**Re: PA22-040 – 87th & 40th PRD – Technical Review 3
4218 / 4112 / 4018 / 3922 / NNA 87th Ave NE
CORE Project No. 21036**

The purpose of this letter is to provide a response to the review comments for PA22-040 – 87th & 40th PRD – Technical Review 3 - 4218 / 4112 / 4018 / 3922 / NNA 87th Ave NE dated January 2, 2024. We have addressed each comment and revised the plan/documentation accordingly. This letter contains the review comments immediately followed by our response to each in bold lettering.

SHEET	OF
C7.21	30

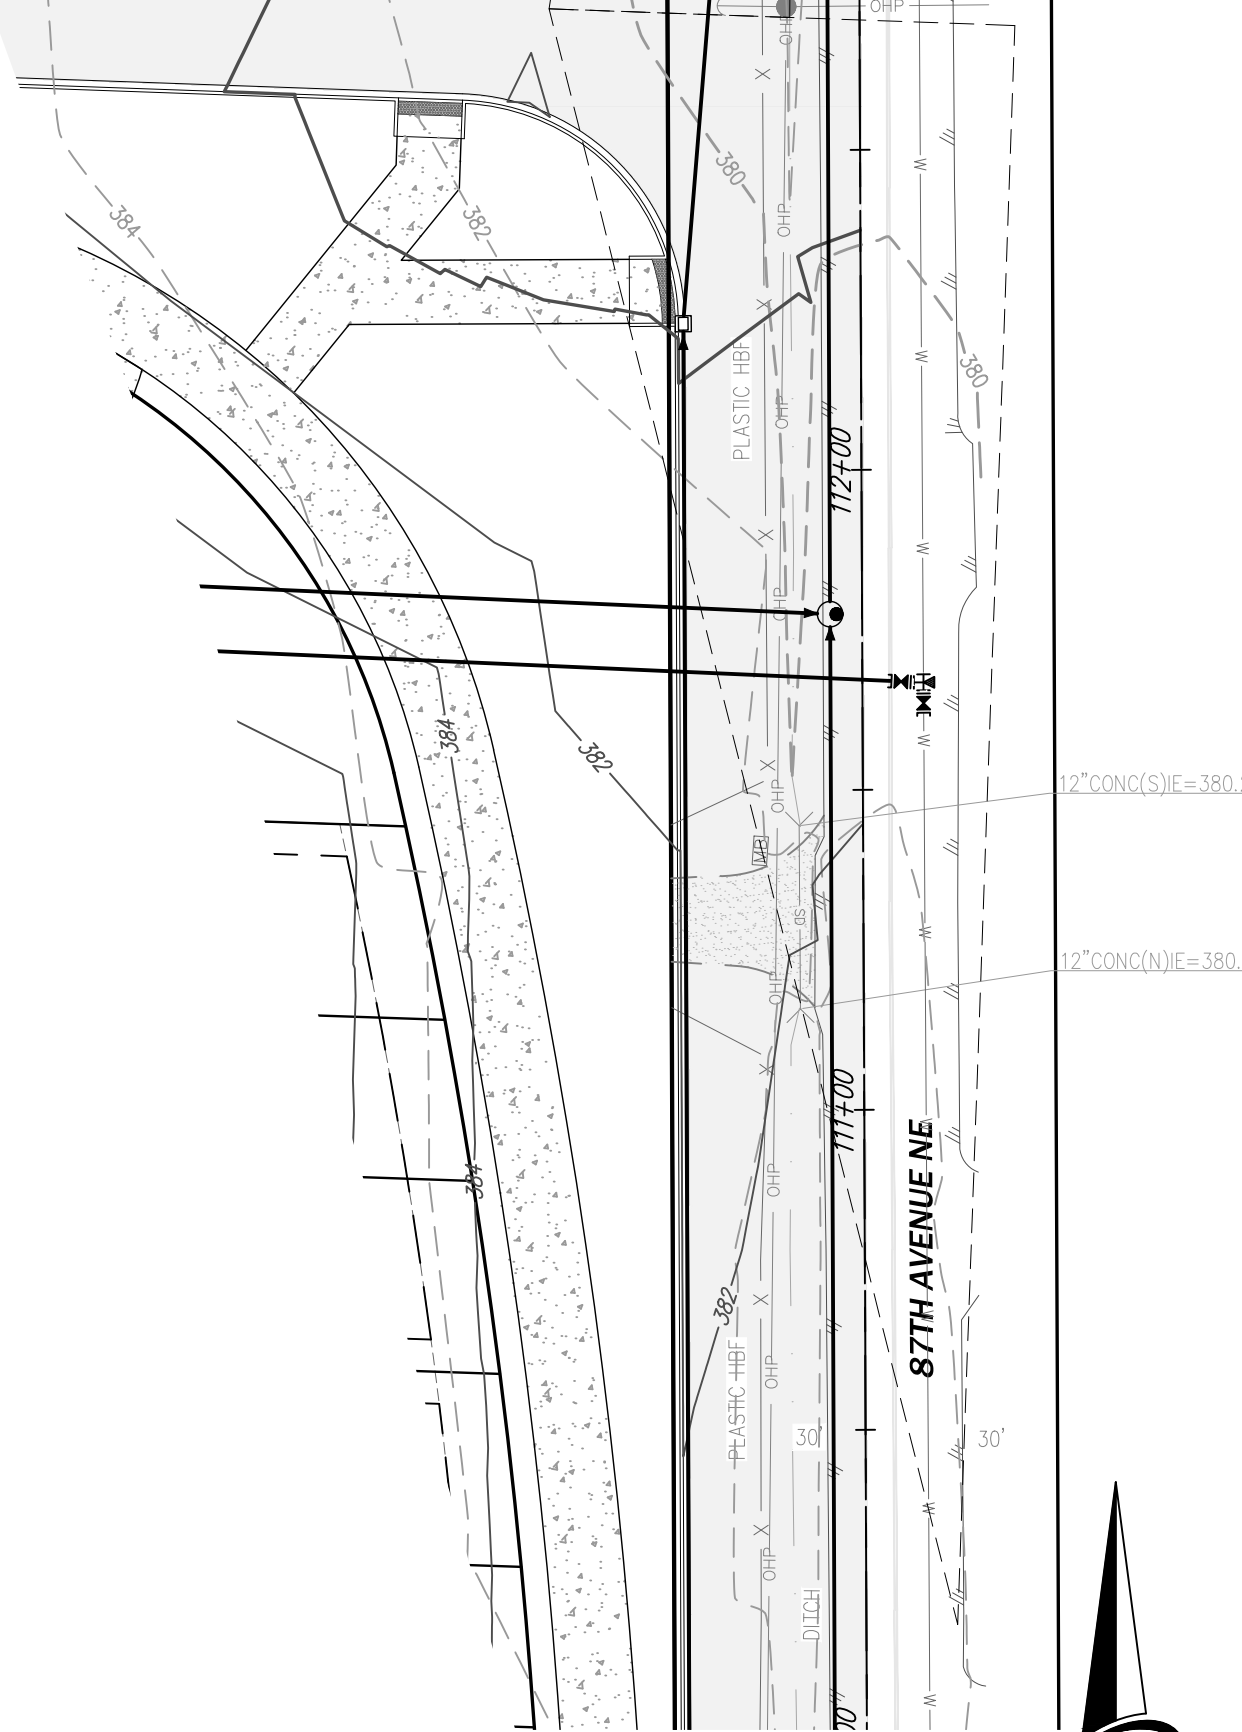
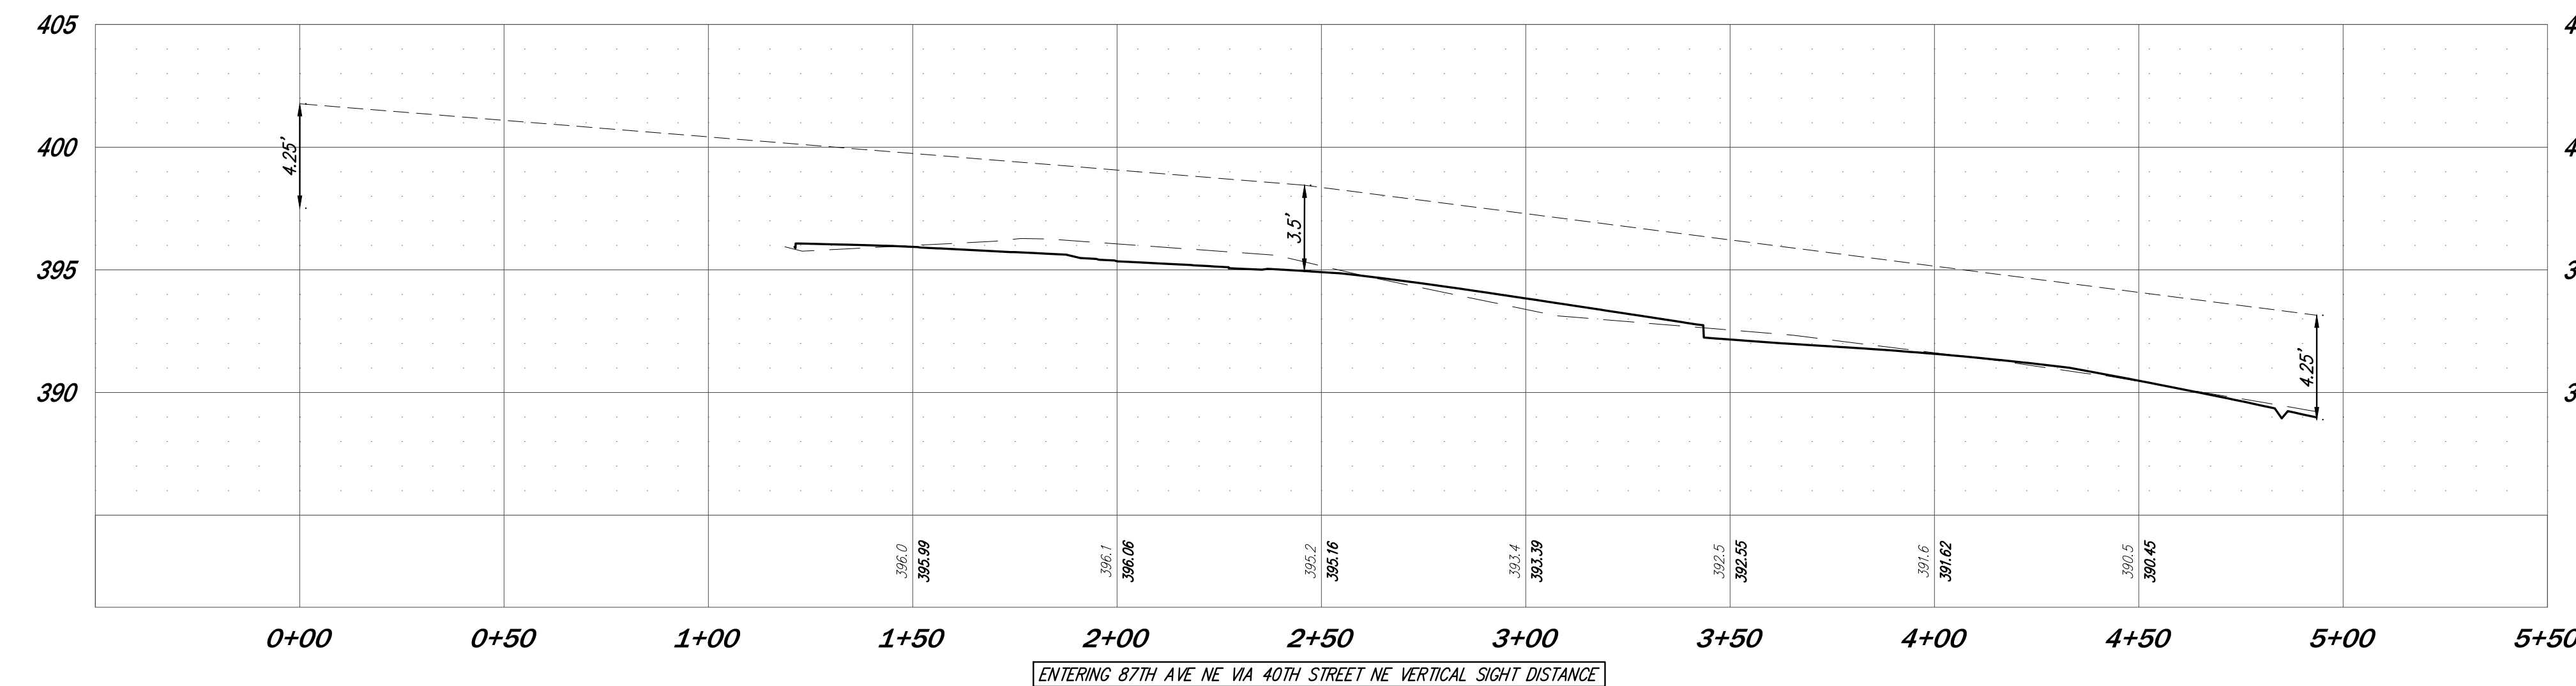
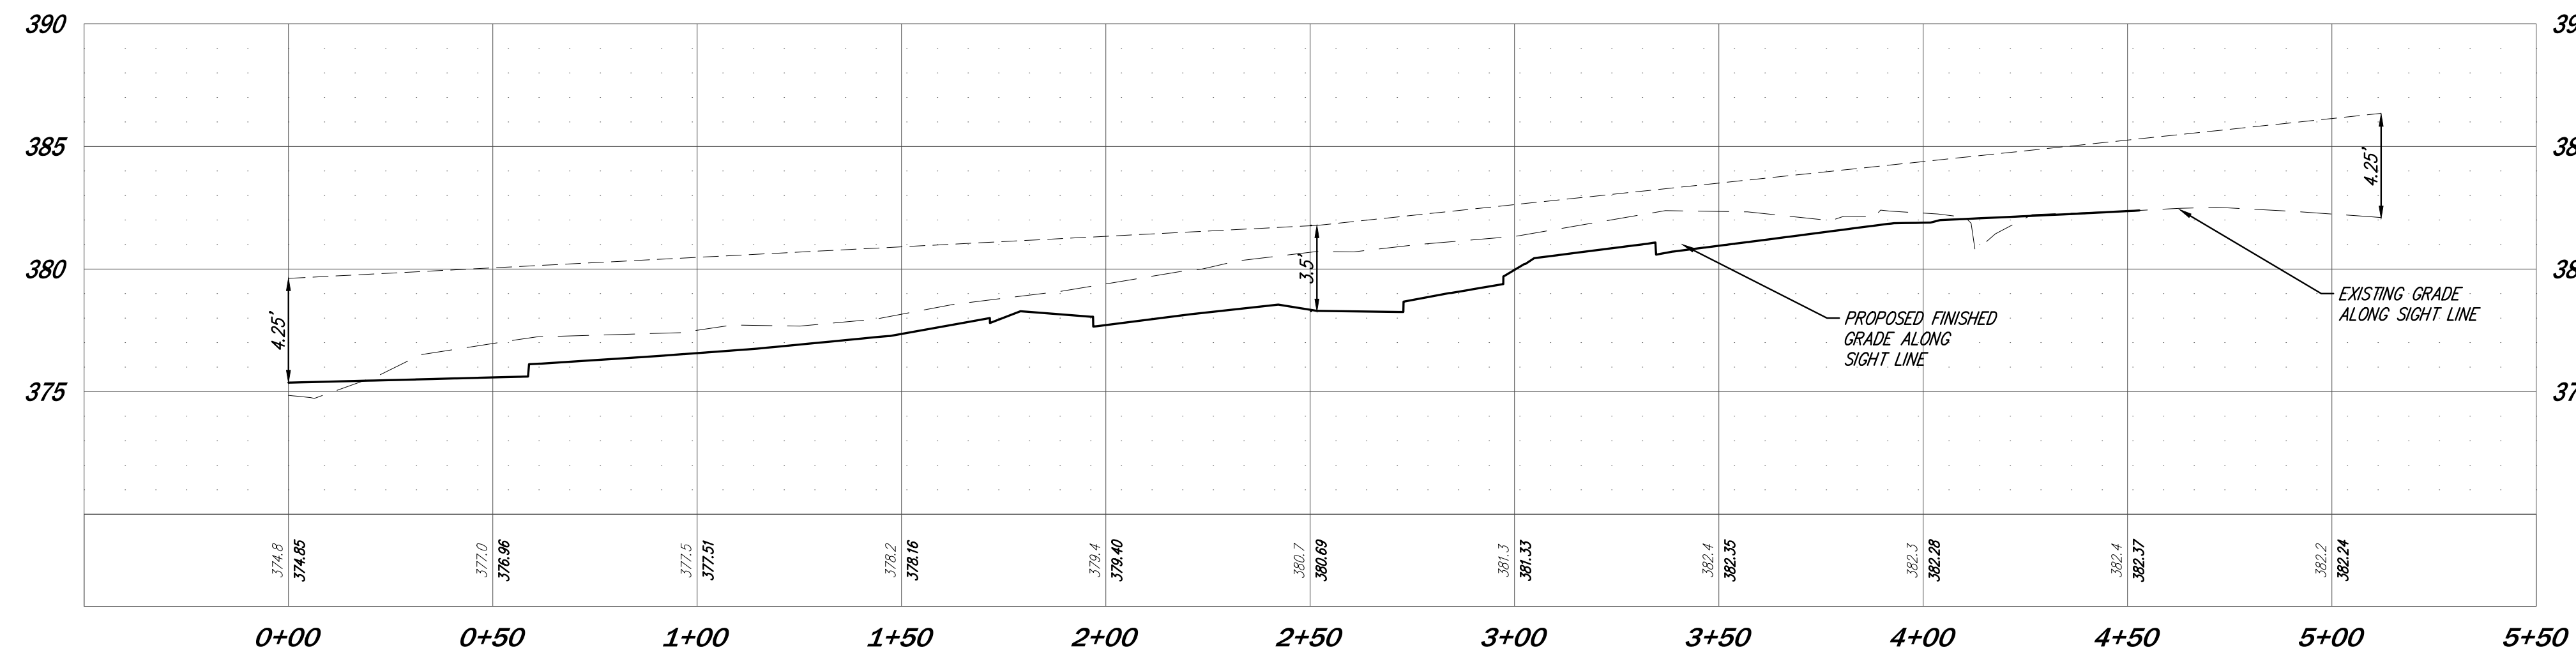
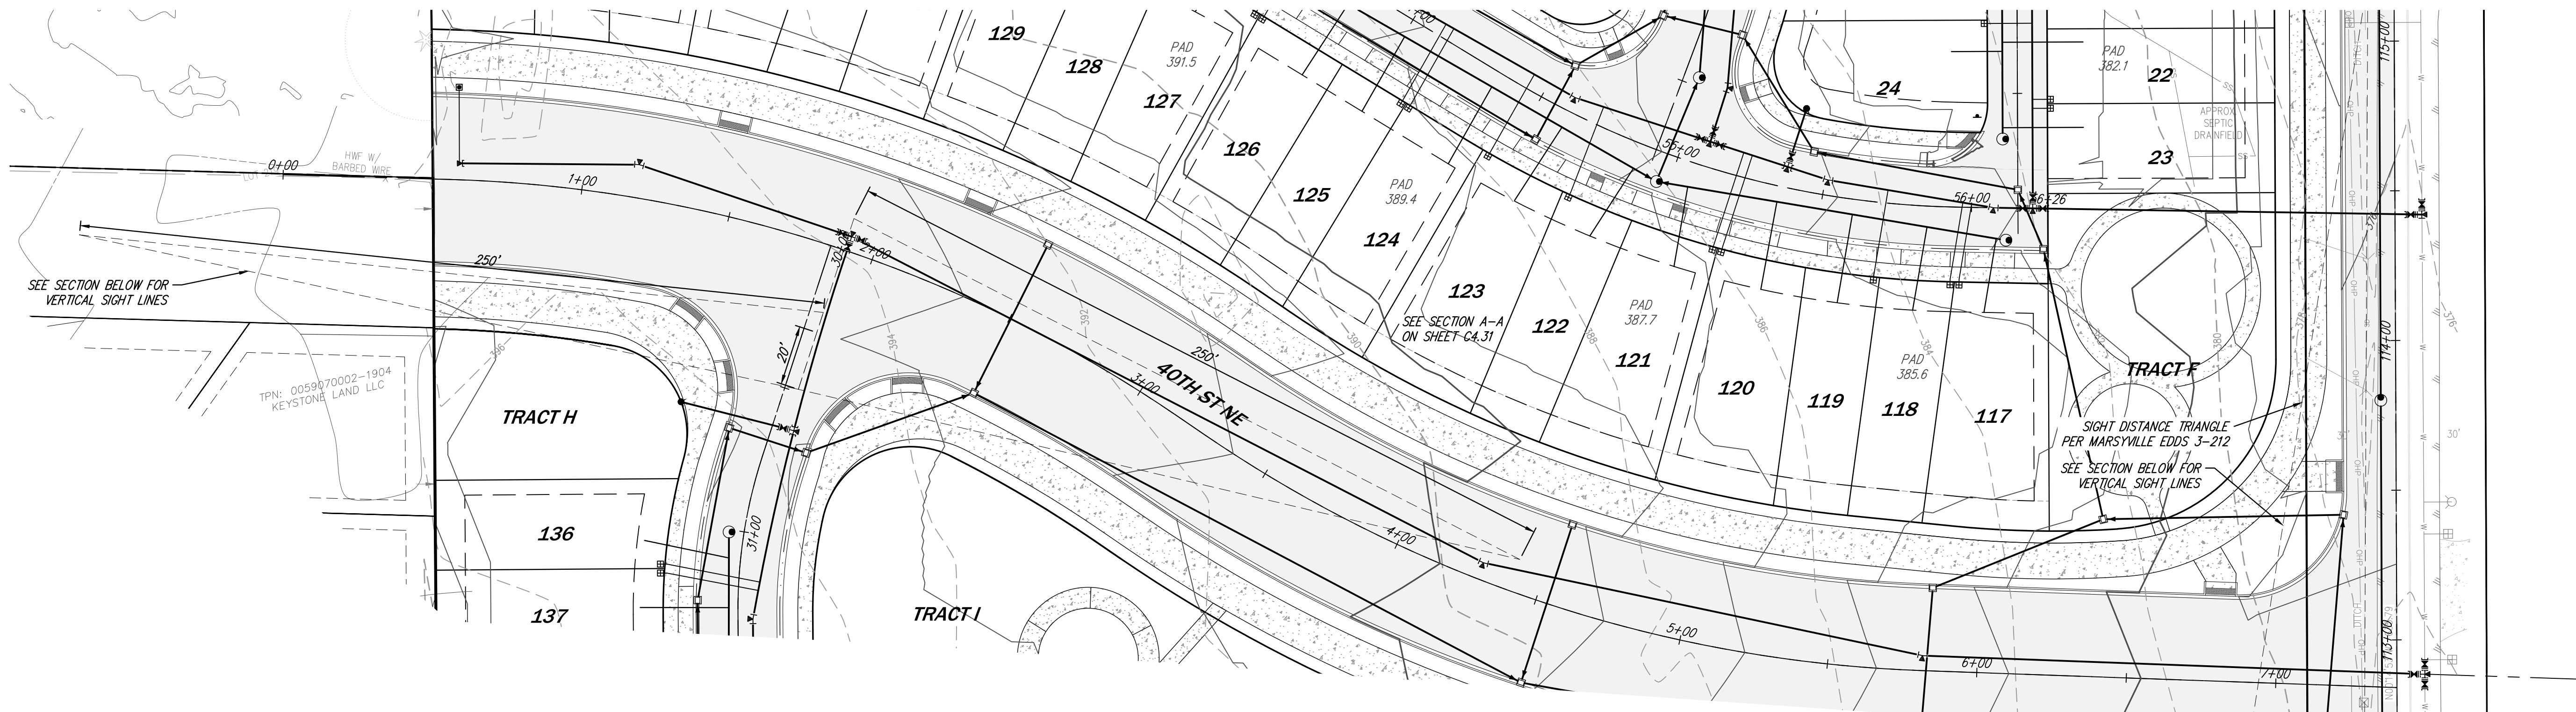
3. Per EDDS 3-312, Intersection sight distance for both new roadways shall be evaluated.

- a. Sight Distance shown on plans appears to be Stopping Sight Distance rather than Intersection Sight Distance.

- b. For 40th ST NE, roadway speed shall be assumed as 35 mph, not 25 mph.

- c. Based upon information shown, it does not appear that sight distance is likely to be inadequate, however plan sheets shall be updated for confirmation of such based upon intersection sight distance with corrected speed limit.

Response: Intersection sight distance is evaluated for each roadway on sheets C7.21-C7.23.

Response: Sight distance triangles have been revised to match entering sight distance requirements.

Response: Sight distance triangles have been revised accordingly.

Response: Sight distance has been revised to match entering sight distance and speed limit per comments.
